Response to Planning application from Hertfordshire County Council (T and CP GDP Order 2015)

District ref: 6/2024/1162/COND
HCC ref: WH/21478/2024
HCC received: 1 July 2024
Area manager: Manjinder Sehmi
Case officer: Shamsul Huda

29 Broadwater Road Welwyn Garden City Hertfordshire AL7 3BQ

Submission of details pursuant of conditions 1 and 24 (Construction Management Plan) on planning permission 6/2019/3024/MAJ

Proposed S278 Layout

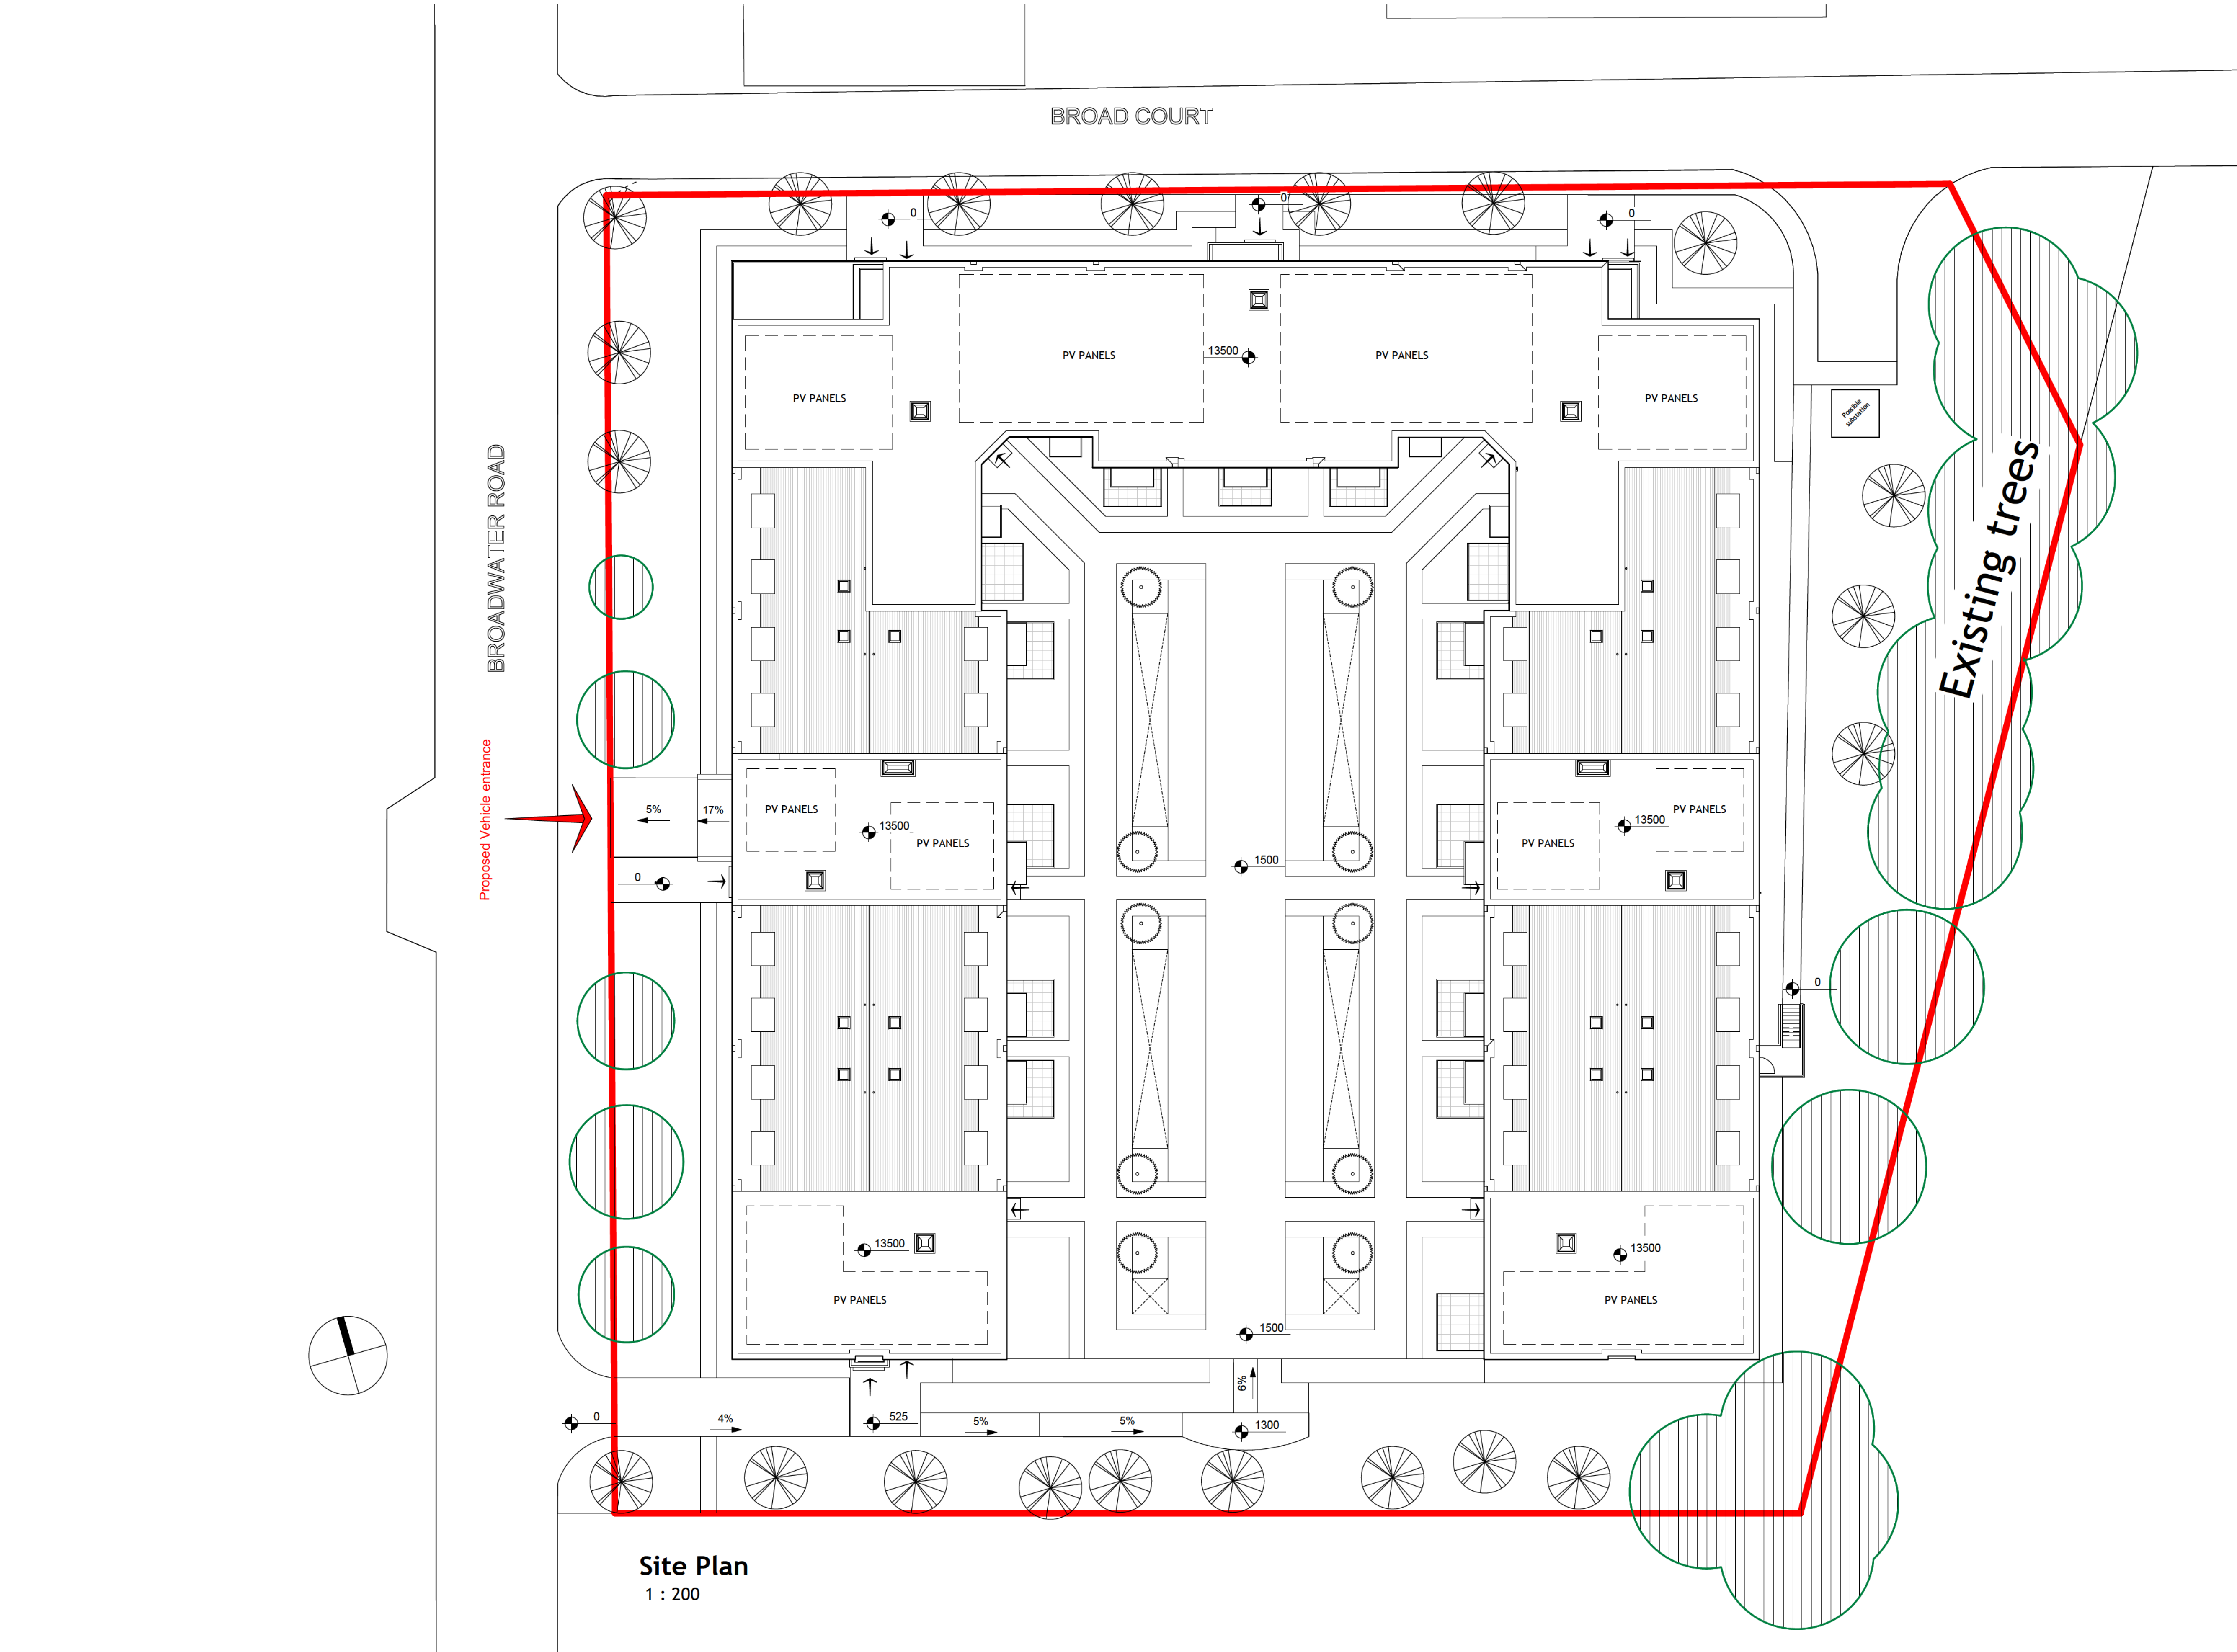
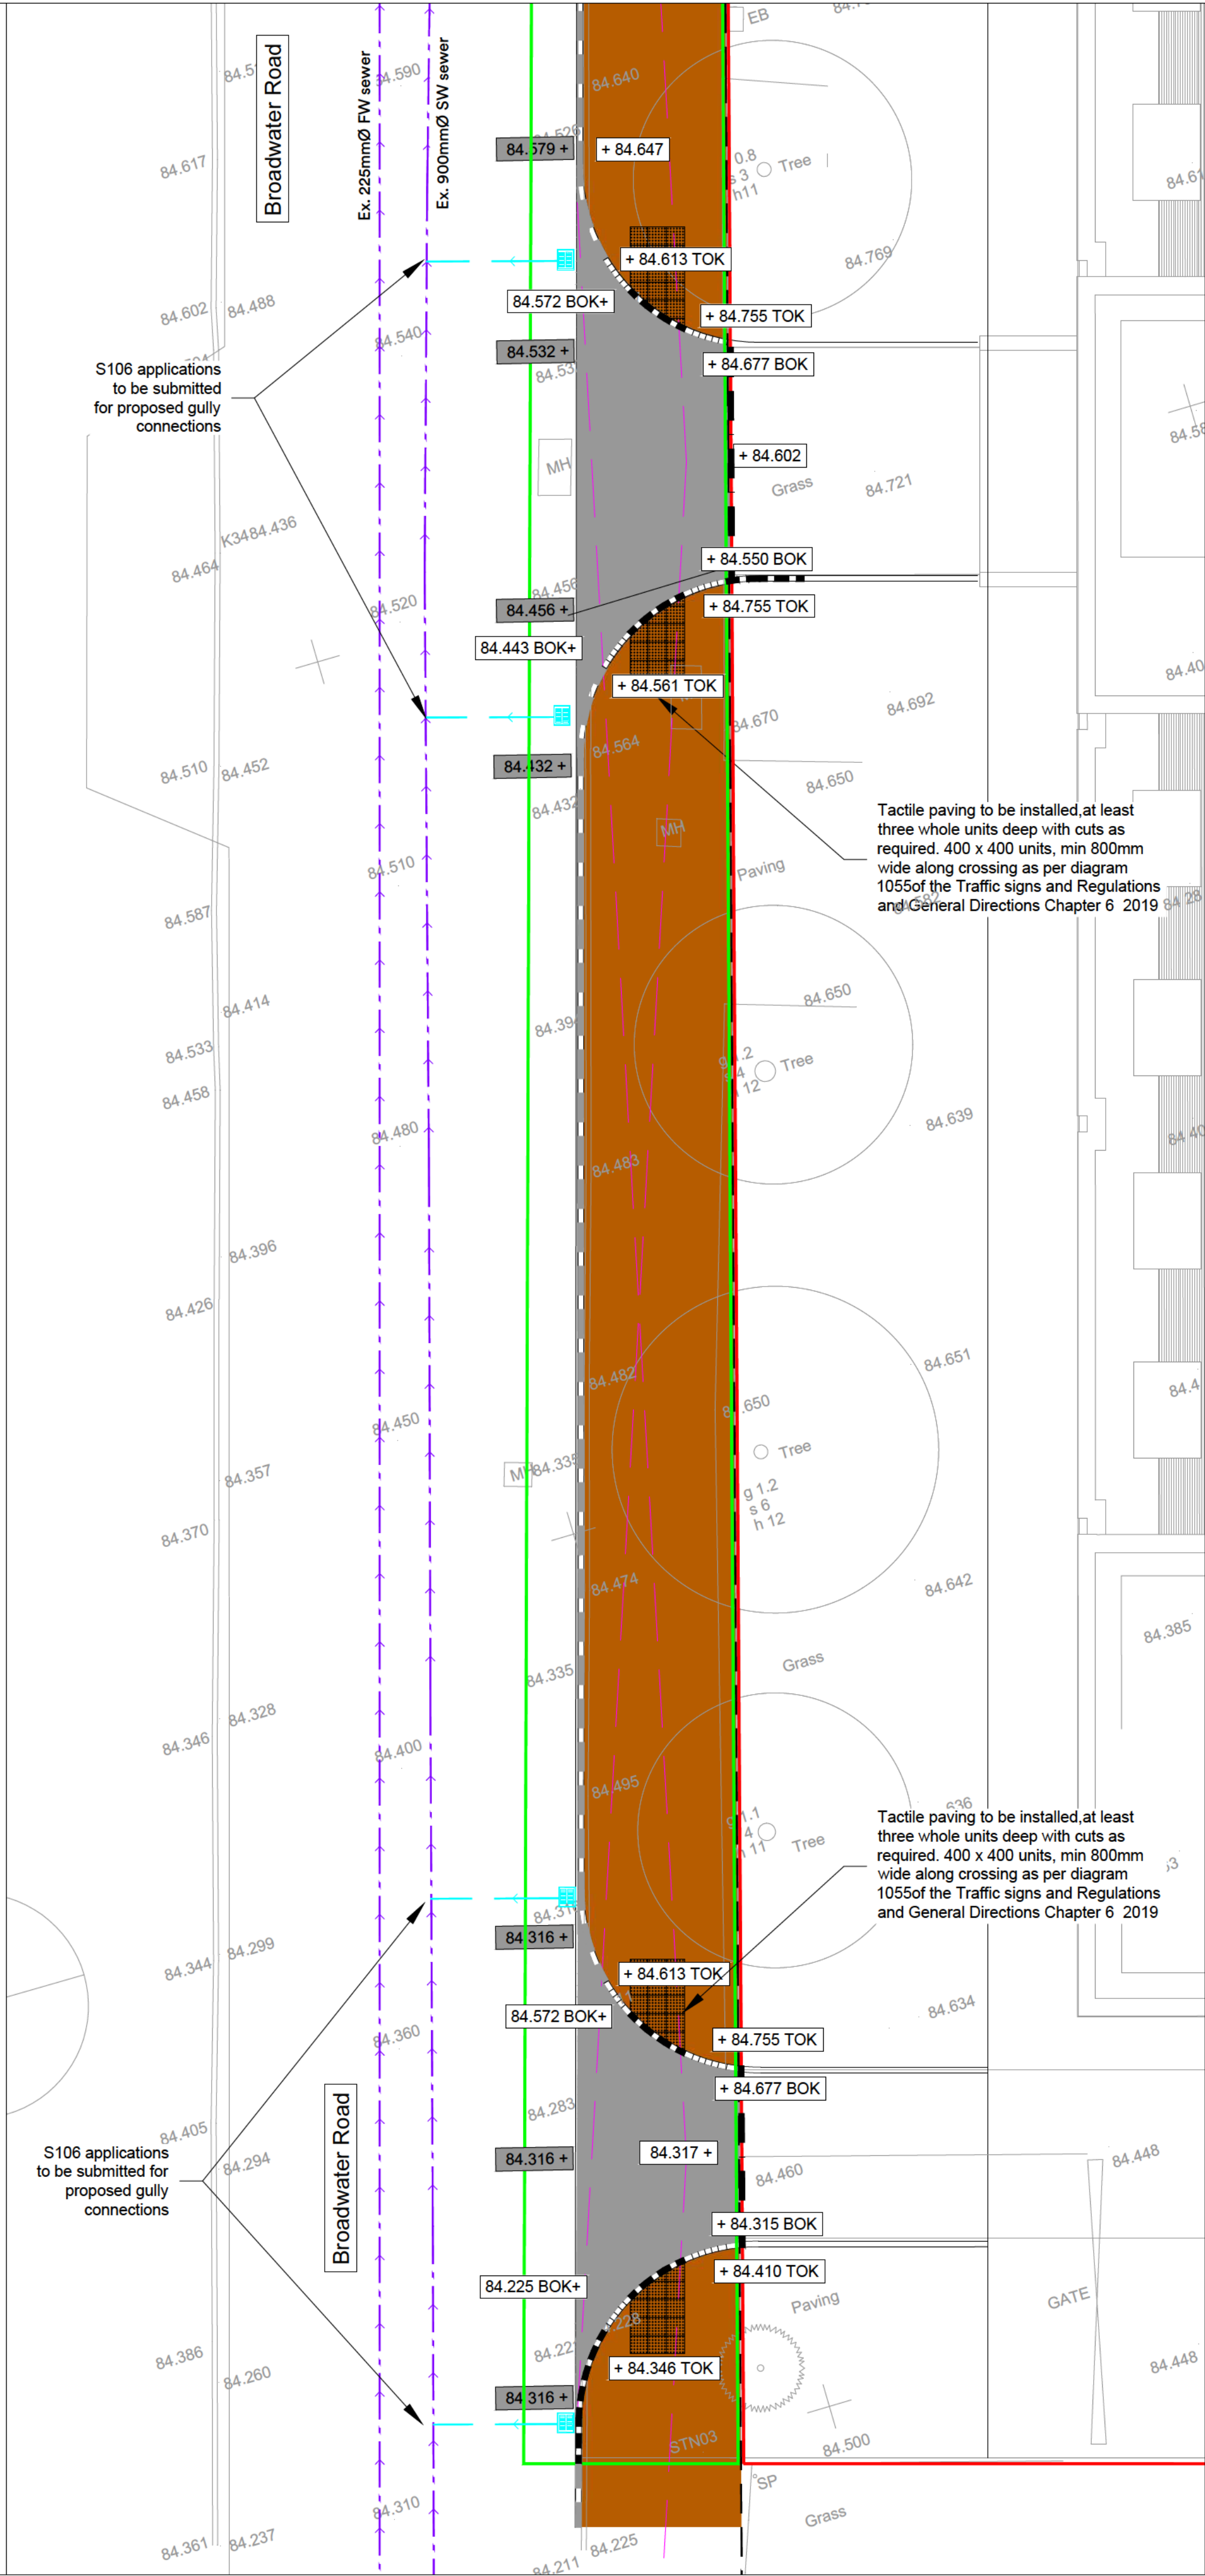
It shows that the submitted CMP includes incorrect context of s278 works. Two site access points off Broadwater Road are included in the appendix E, which shows the scope of the s278 works, in conflict to the planning requirements 14 and 15. In accordance with condition 15, only the central access (main access) shall be allowed to access the site; all other access points, including the south entrance, should be permanently closed off Broadwater Road .

Thus, it is recommended that the applicant submit the CMP again together with the accurate scope of the S278 works.
